Site Development Plan - Comment Response Letter

Citizen on Constitution
El Paso County, Colorado

PCD File Number: PPR-2229

SITE DEVELOPMENT PLAN – COMMENT RESPONSE

L601

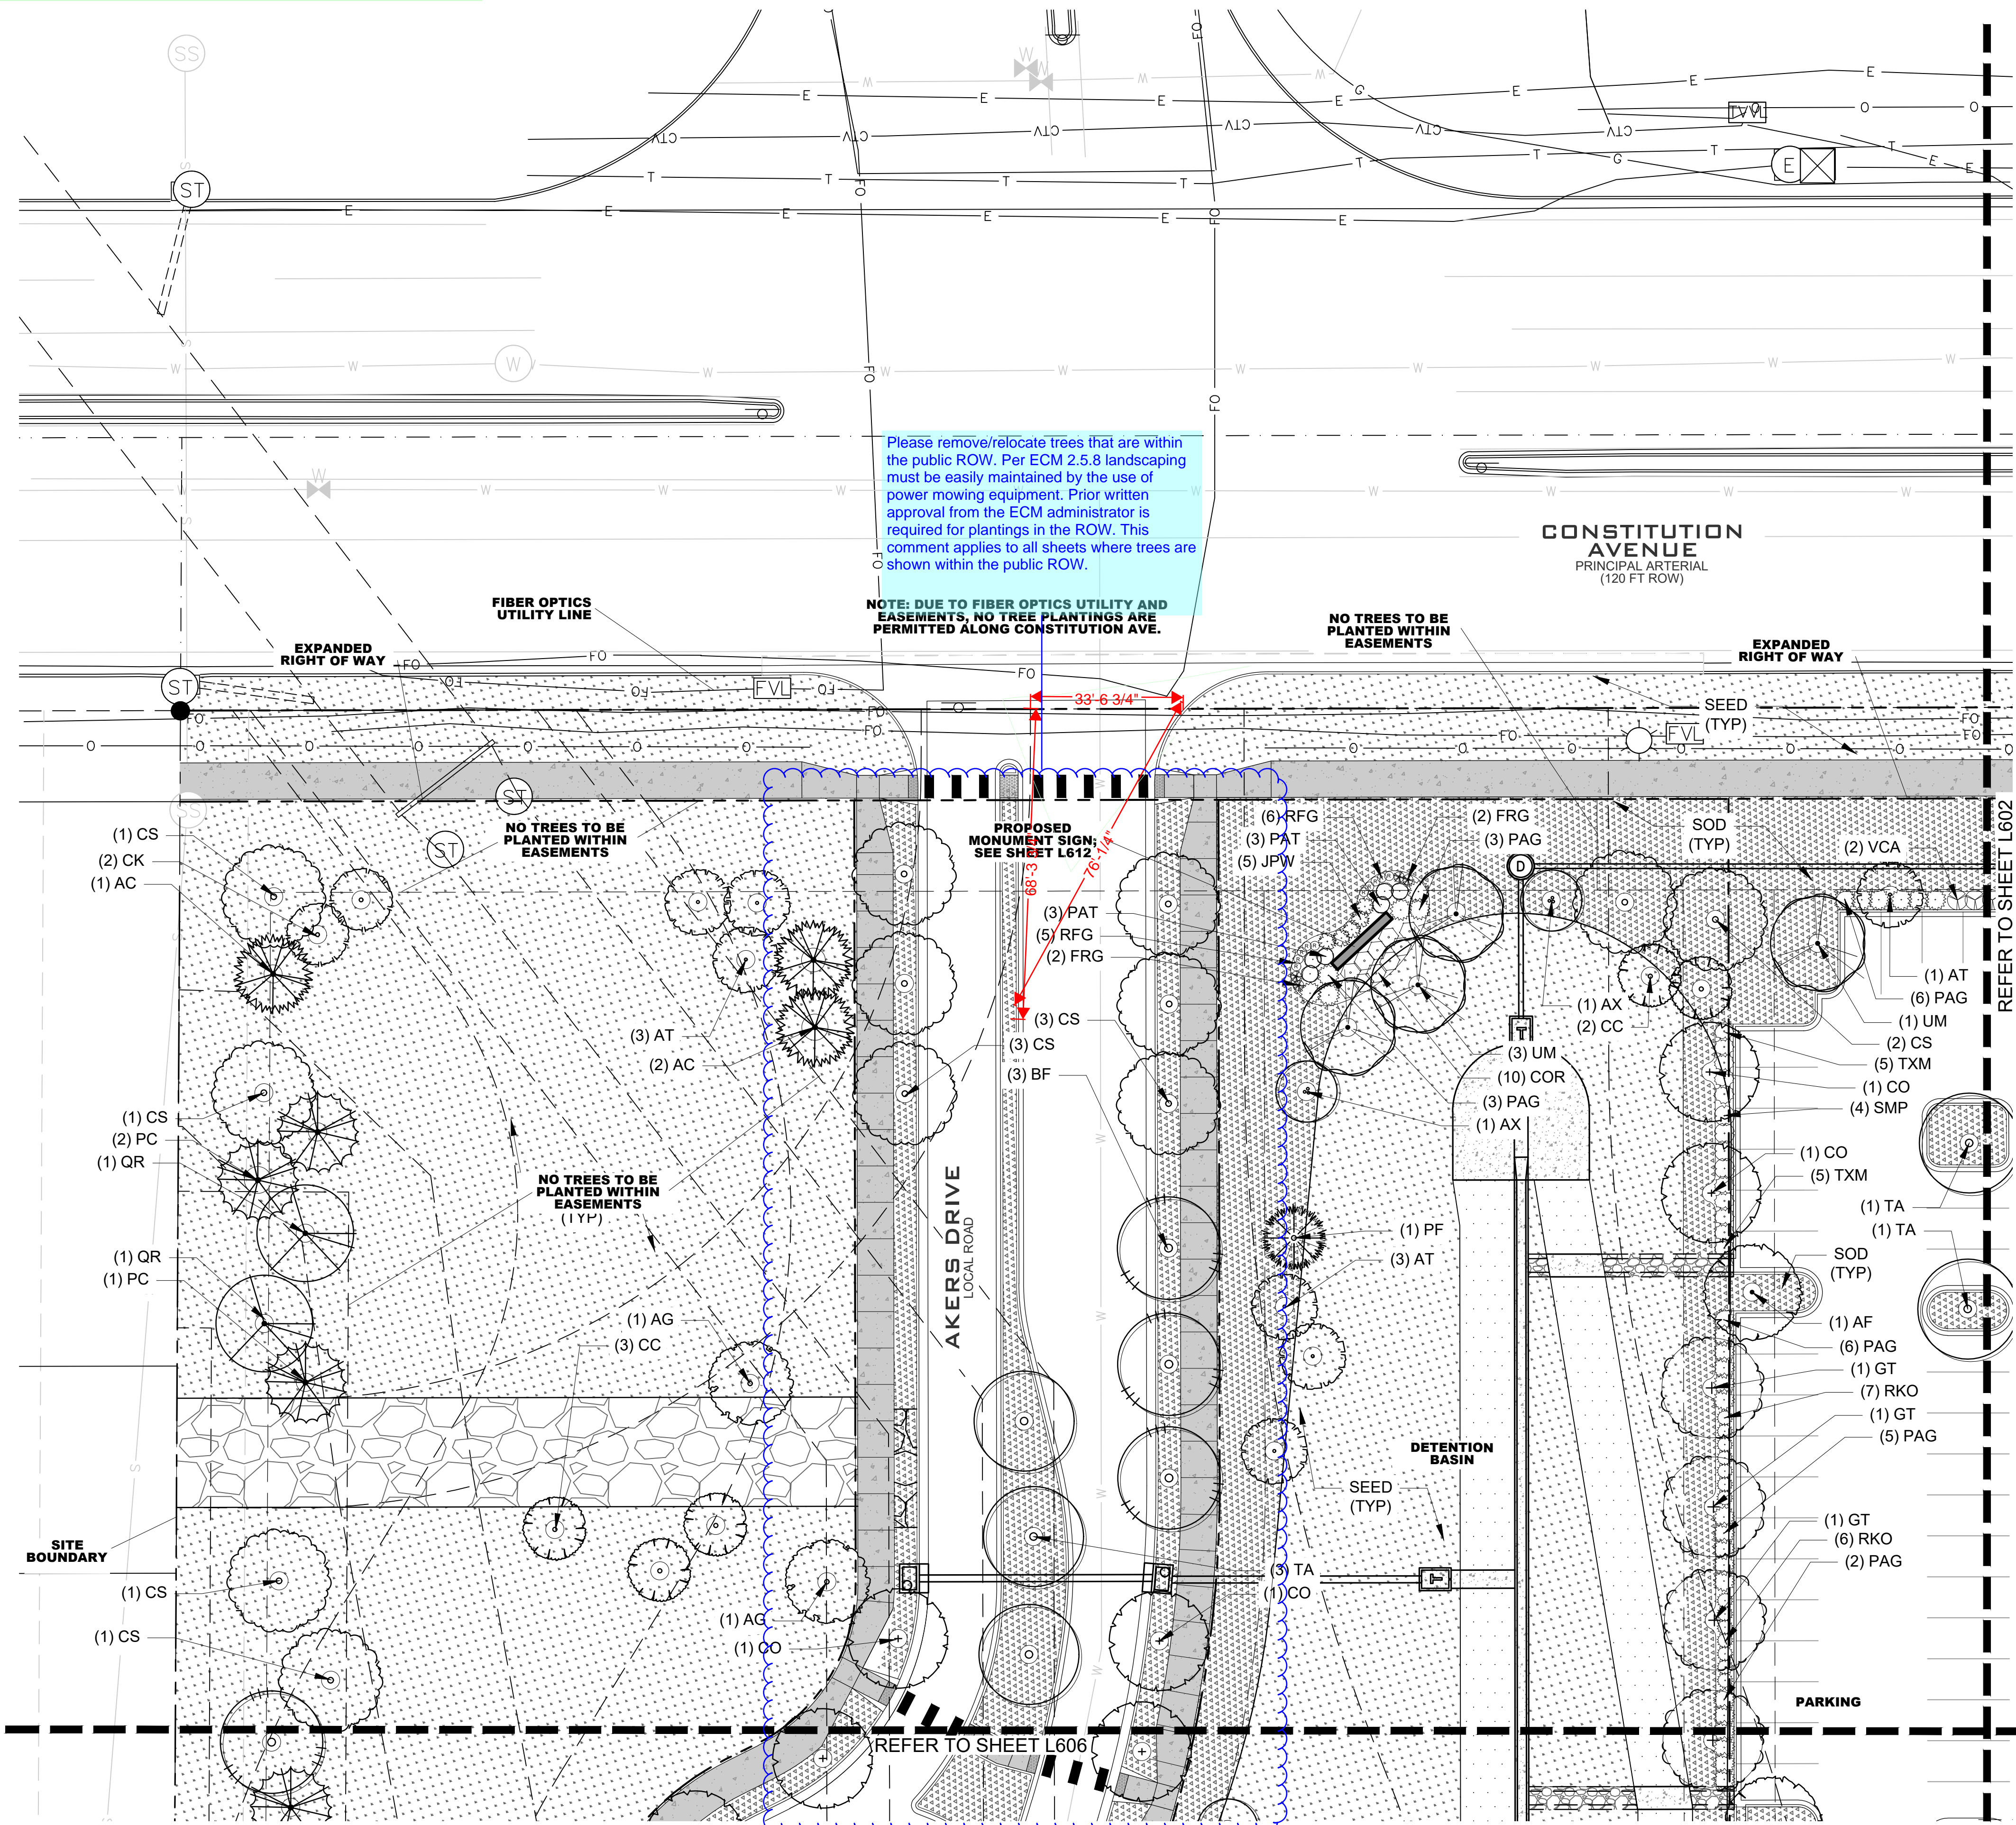
2. SHEET L600: "Please update the file number to PPR-22-29"
RESPONSE: Updated on all sheets.
3. SHEET L601 (also referenced on SHEET L606): "Please include: Show the sight distance, that nothing is within the 25-ft of the ROW Section 6.2.2.g.iii"

4. SHEET L601: "Please remove/relocate trees that are within the public ROW. Per ECM 2.5.8 landscaping must be easily maintained by the use of power mowing equipment. Prior written approval from the ECM administrator is required for plantings in the ROW. This comment applies to all sheets where trees are shown within the public ROW.

RESPONSE: A setback line has been included in all landscape plan sheets to show the 25' Setback. Section 6.2.2.g.iii states that "Use of Box Elder, Salix, and Populus Limited. Box Elder (*Acer negundo*) and all trees of the *Salix* and *Populus* genus, except Aspen (*Populus Tremuloides*), shall not be planted within 25 feet of a right-of-way." Drawings have been adjusted to ensure that this is met.

RESPONSE: All trees have been removed from the R.O.W. on all sheets.
5. SHEET L602: Please include gross square footage of property. Required versus provided plant count in relation to total square footage.

L602

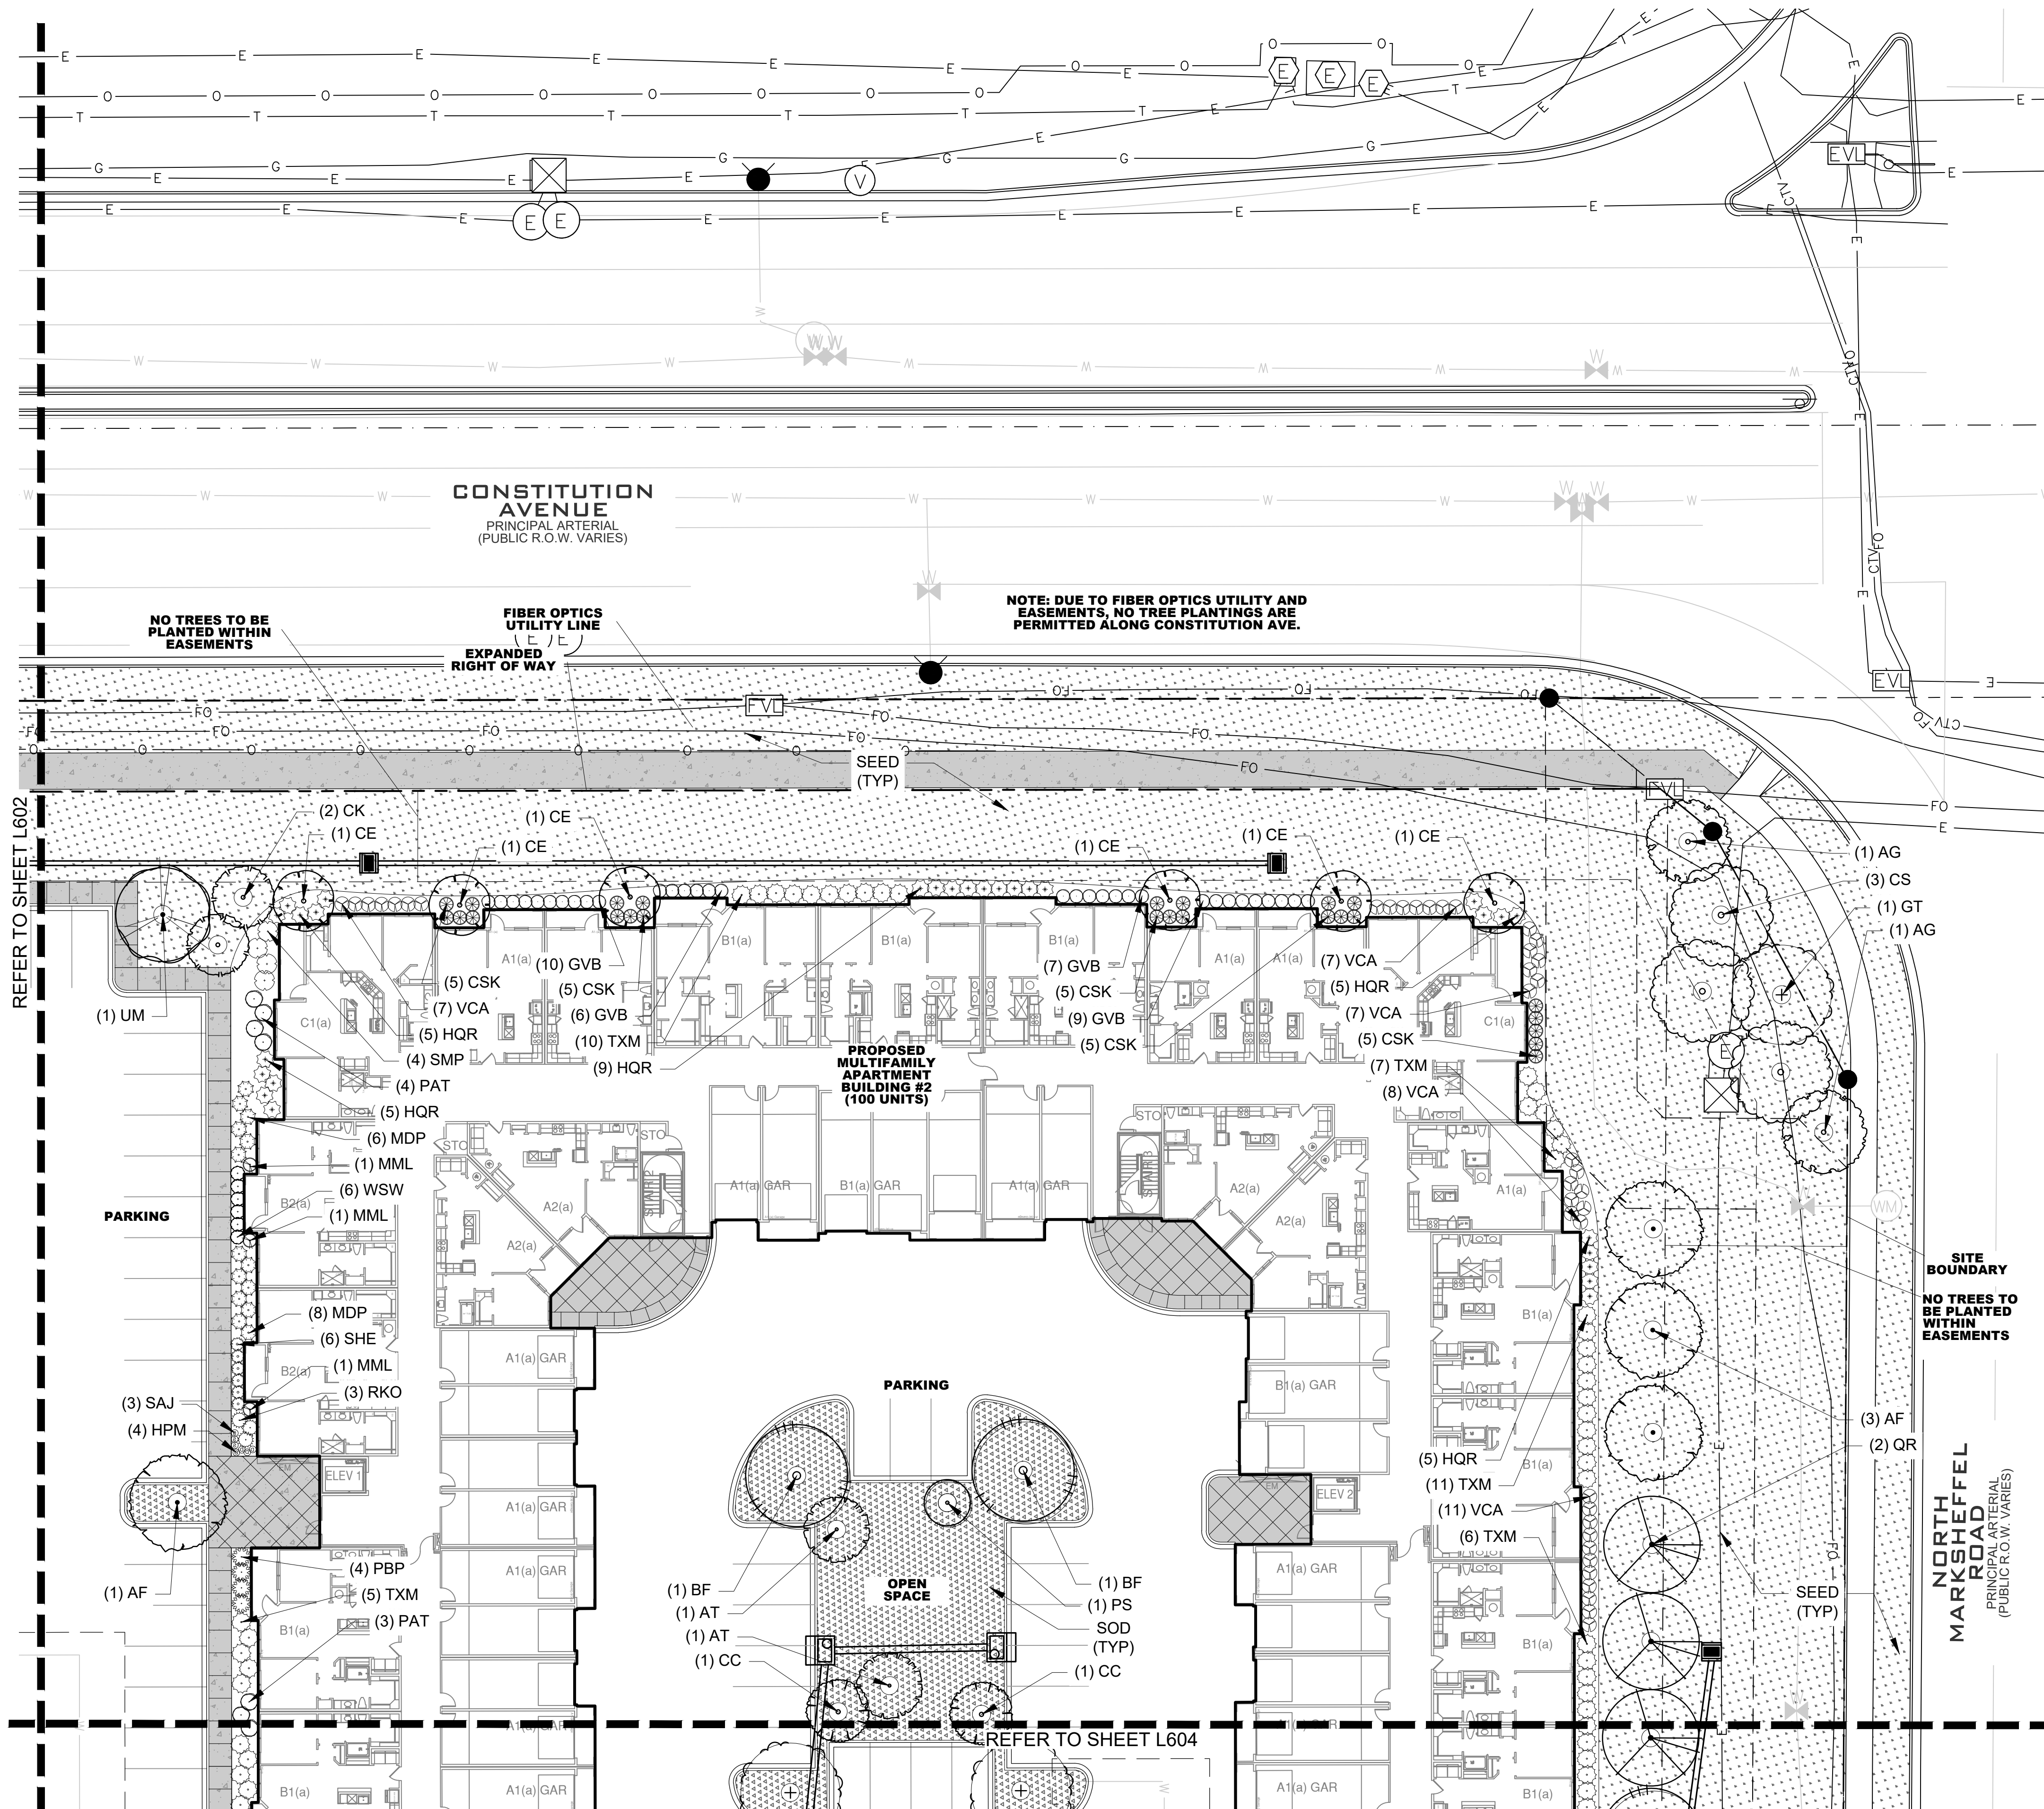
6. Please indicate: (1) total gross square footage of property (2) required versus provided plant count in relation to total square footage.

RESPONSE: Gross square footages as well as required/provided plant counts have been added to the bottom of the plant schedule on each sheet.

RESPONSE: Information in regards to total gross square footage and plant requirements in relation to the overall site has been included on each plan sheet (L601-L608). (This information is in relation to Land Development Code Section 6.2.2.E.3)
